From: Contact Centre (CRM) <contact@ribblevalley.gov.uk>
Sent: 25 June 2022 17:06
To: Planning
Subject: Planning Application Comments - 3/2022/0532 FS-Case-432271858

Planning Application Reference No.: 3/2022/0532

Address of Development: 39 The Rydings, Langho BB6 8BQ

existing ground floor plan

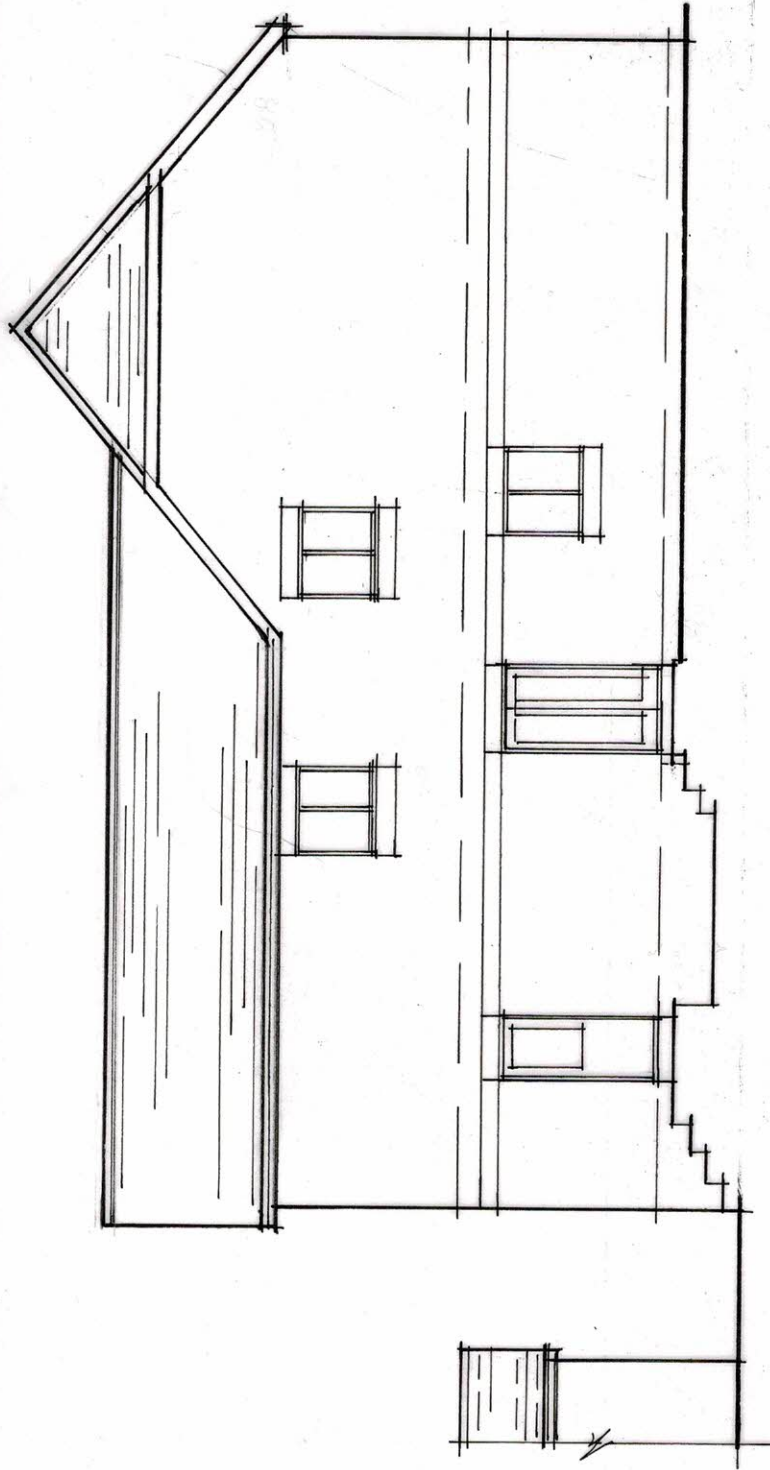
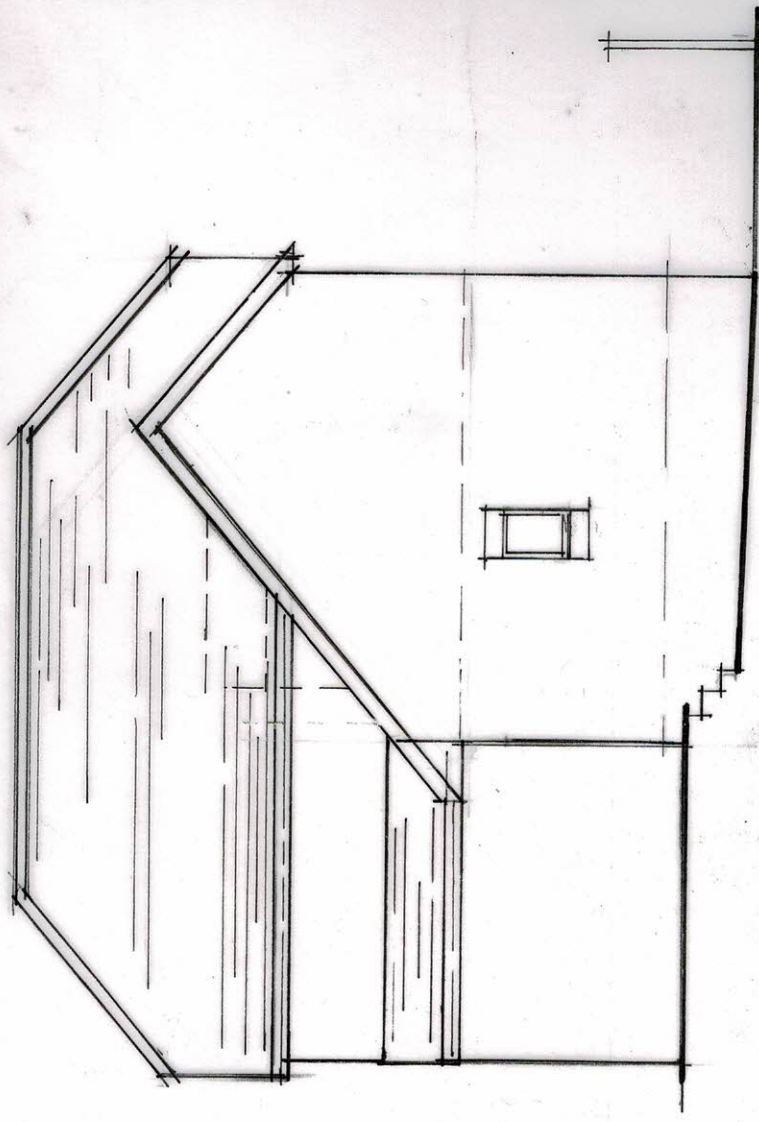
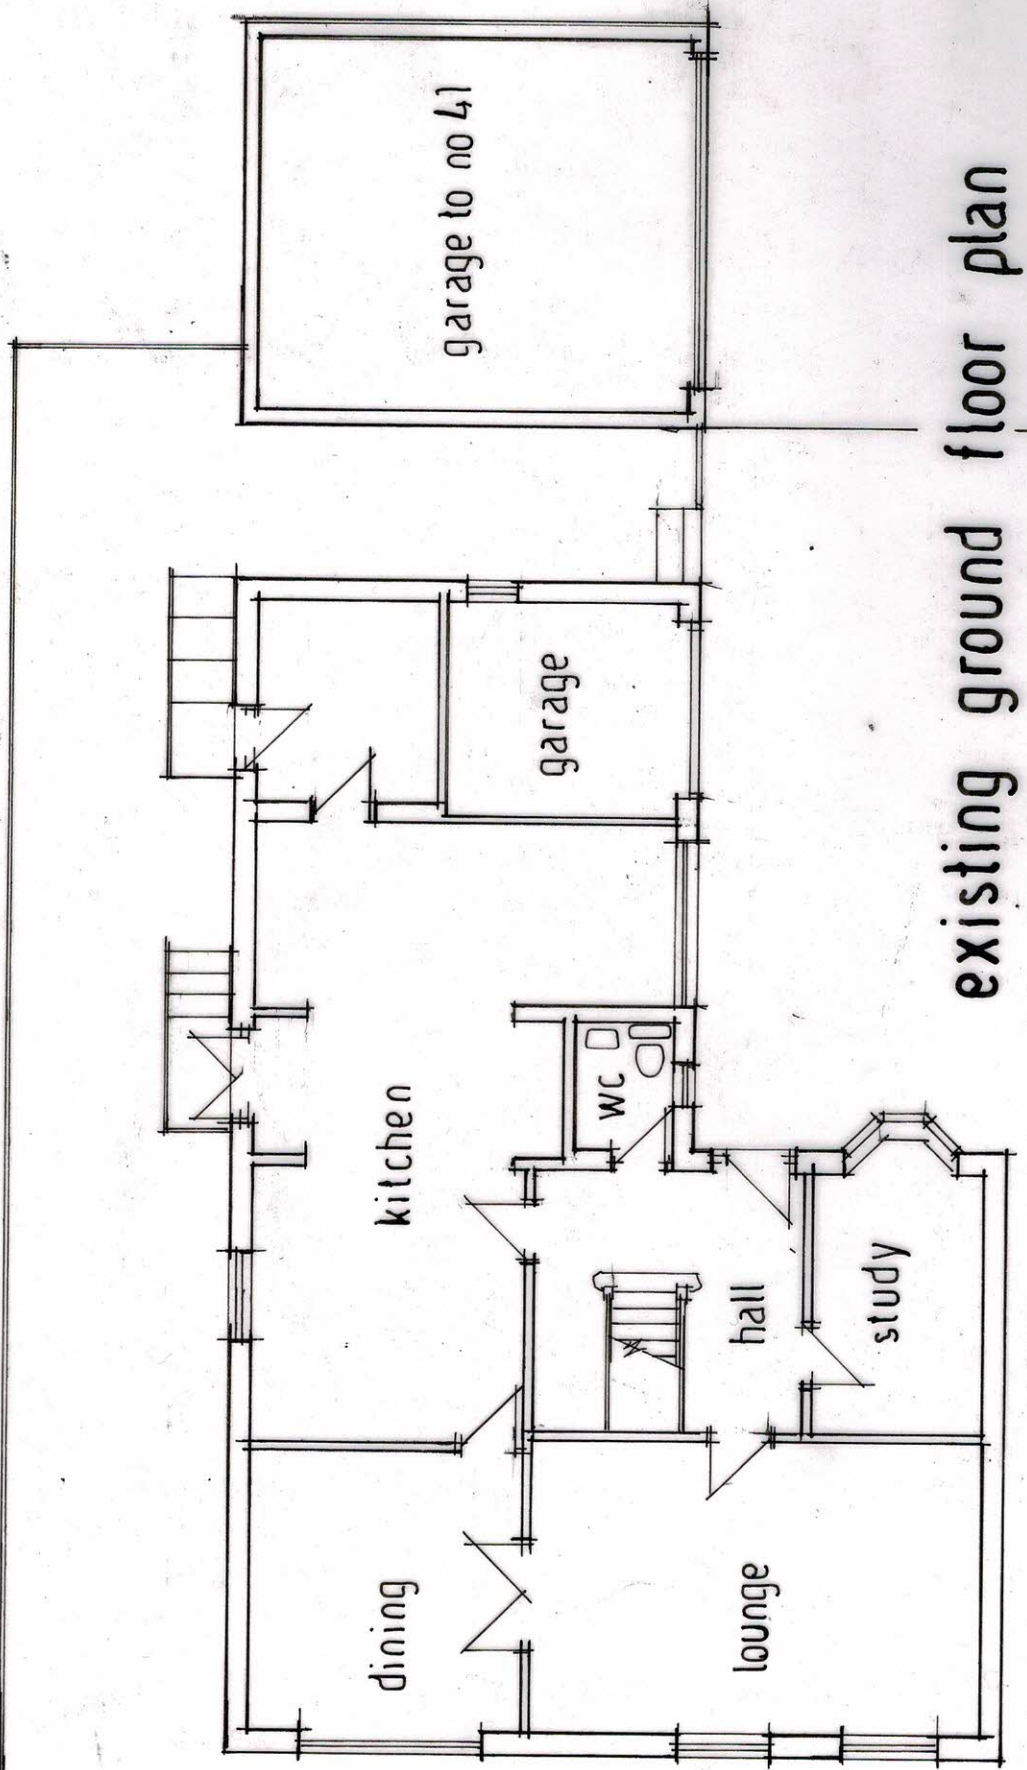
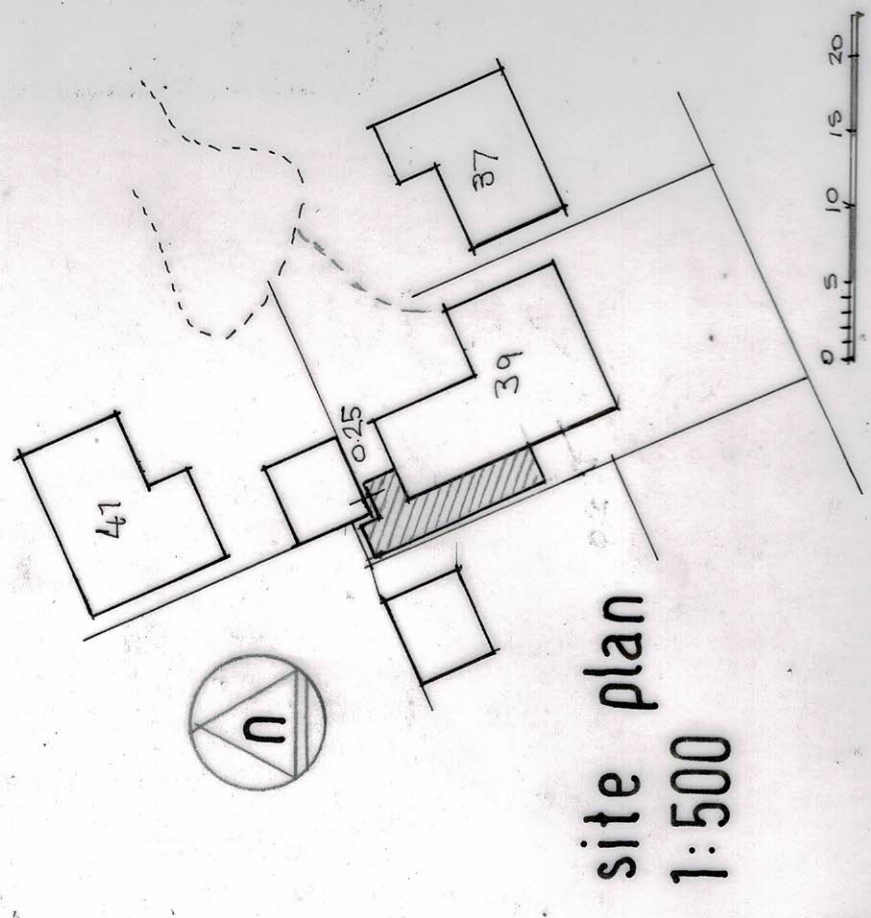
- a) cramming in an rear extension all the way to the western boundary fence to 61 The Rydings and
- b) a side extension taking all the space between the garage to 41 and the northern boundary fence to 59 The Rydings.

The plans do not show the conservatory extension that has already been constructed in the garden and this proposal will take up a significant proportion of the available land surrounding the property.

The roof of the proposed extension will be higher than the existing roofline of the garage to no. 41. The slope of the proposed store roof will contrast significantly with that of the adjoining garage especially when it is built immediately adjoining. Because no.59 is slightly lower in elevation it will be faced with a 5m high brick wall which will tower up to 3m above the existing fence.

sections 1:50

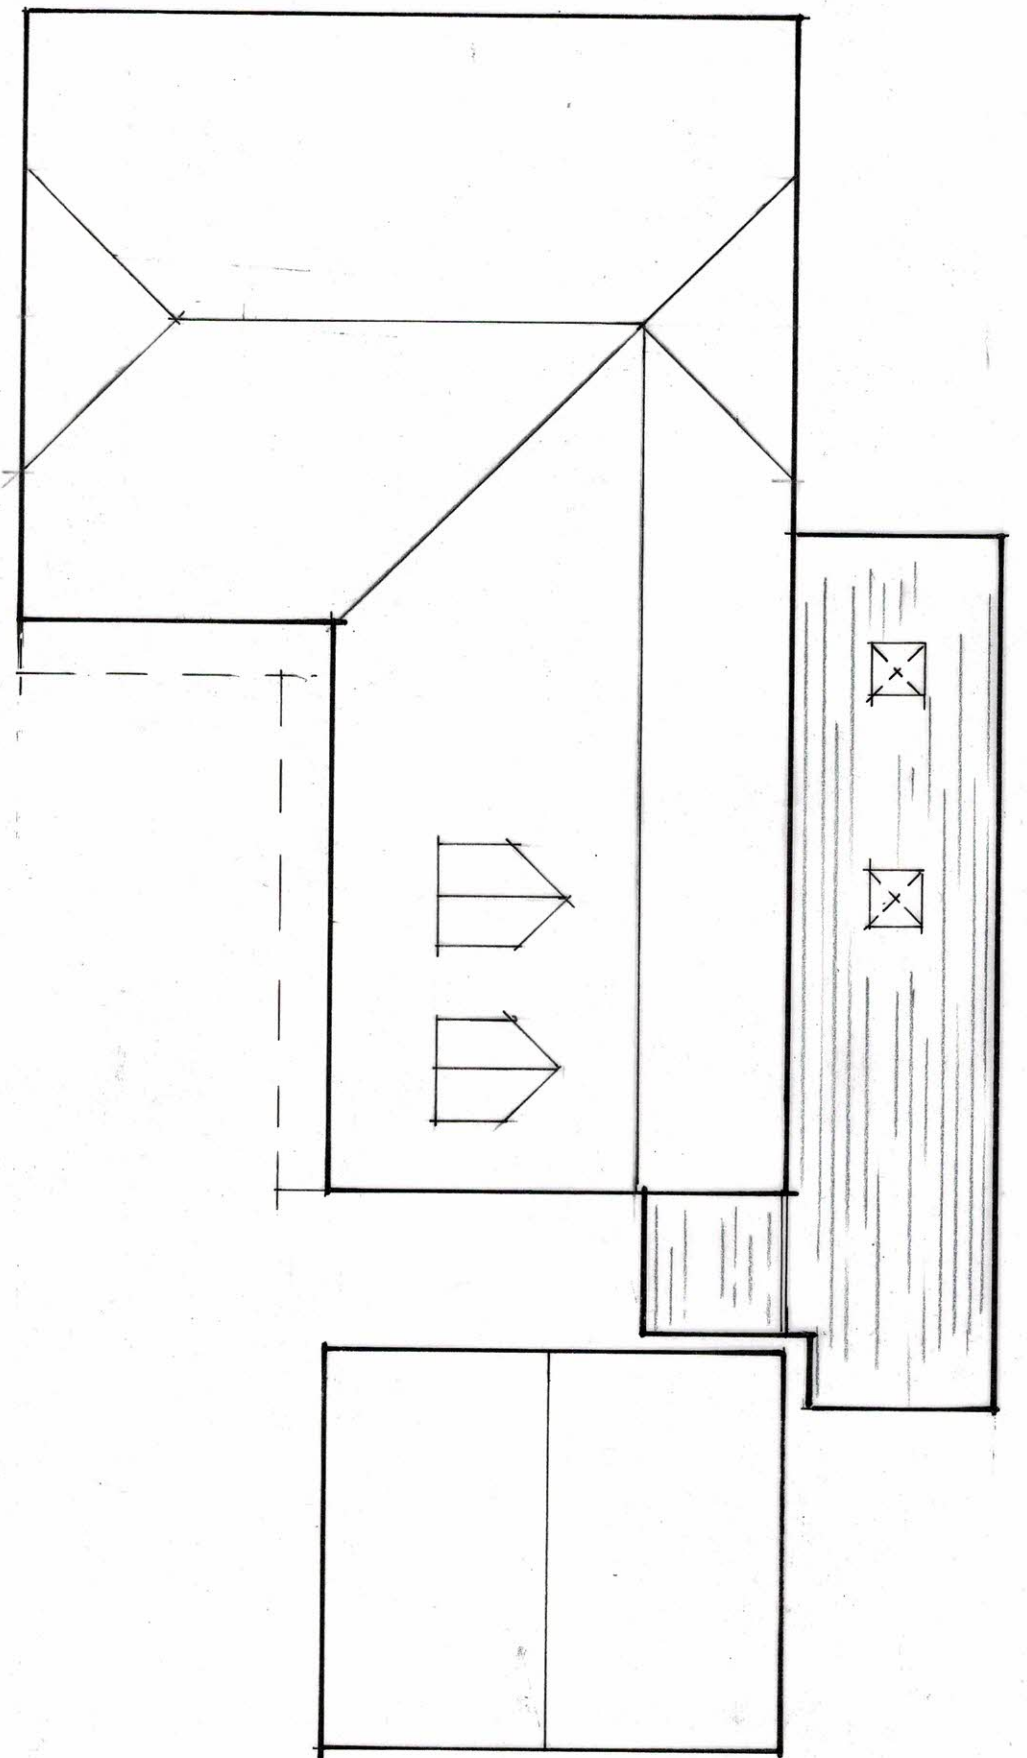
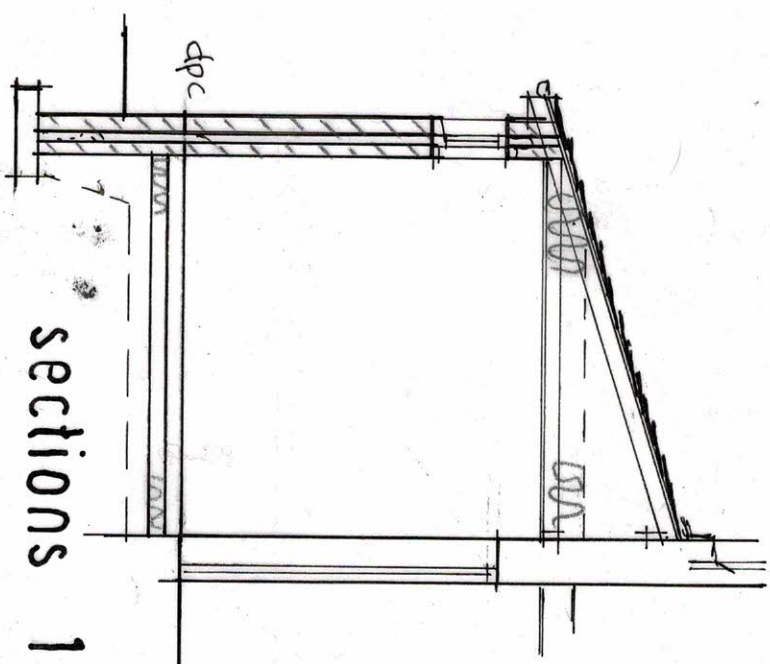
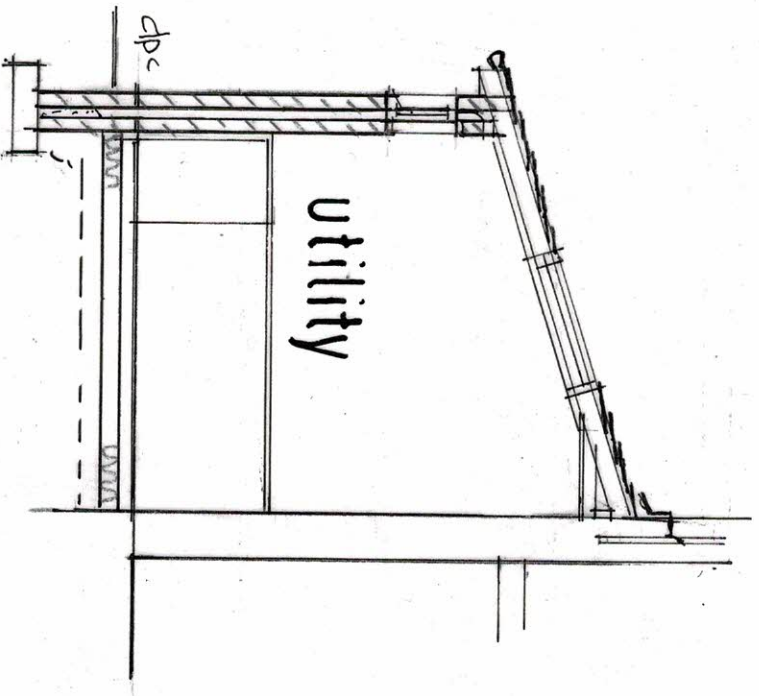
A key consideration for any project is the impact on future maintenance. No mention is made in the proposal for rain water goods and dealing with water from the roof structures. Currently one of the downspouts to the existing gutter at the rear of 39 is blocked with weeds growing out. This leads to water cascading onto the existing hard flagged surface and ponding of water to the rear of no. 59 where the ground level is a foot or more lower. This standing water issue is made worse by the gutters to the rear of the garages to 41 and 61 also getting blocked and surcharging.
